Howerton Services, PLLC
License # P-1716
3513 Cathedral Bell Road
Raleigh, NC 27614
(919) 270-3460

February 20, 2024

Subject: 2680 Peach Farm Road
Lillington, NC 27546
Plan Revision Letter
Harnett County Permit #: BRES2310-0001

FLOOR PLAN
 SCALE: 1/4" = 1'-0"
 UNHEATED AREA: 1000 SQ. FT. IN SIDING
 10FT. CEILING HEIGHT THROUGHOUT

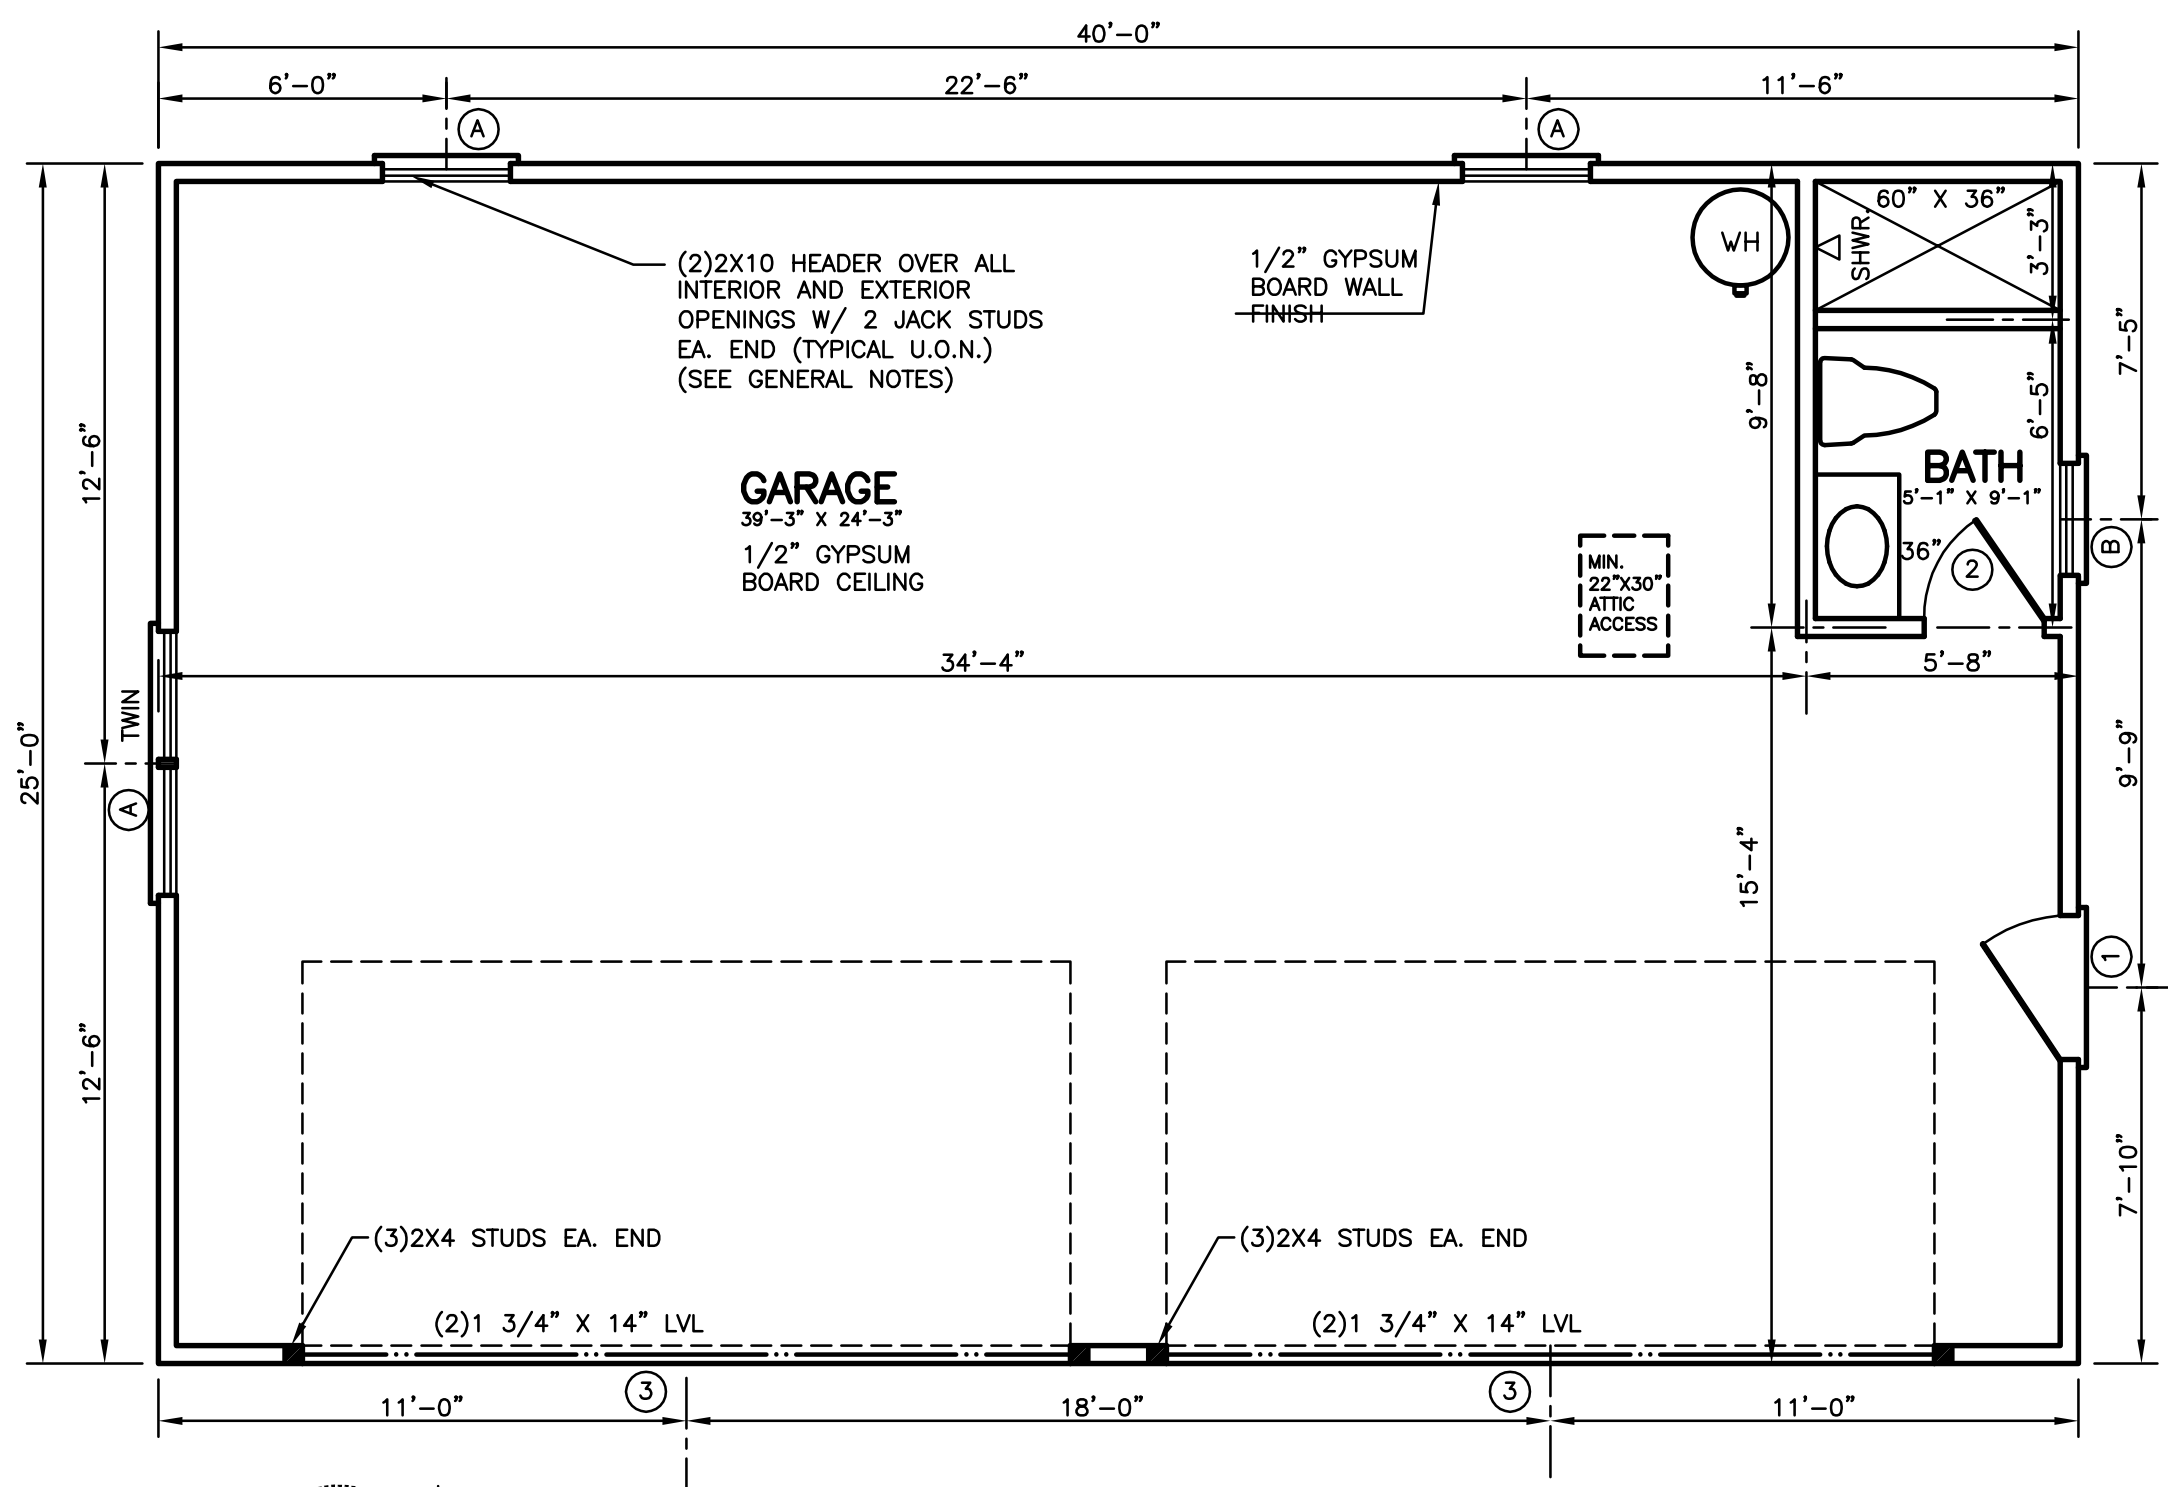
- The plans call for ½” sheetrock on the interior of the exterior Garage walls. The ½” sheetrock is not required on the interior of the exterior Garage walls. The ½” sheetrock is only required on the walls and ceiling of the bathroom inside the Garage. This modification is acceptable.

The plan modification noted above meets all the requirements of the 2018 North Carolina Building Code for Residences.
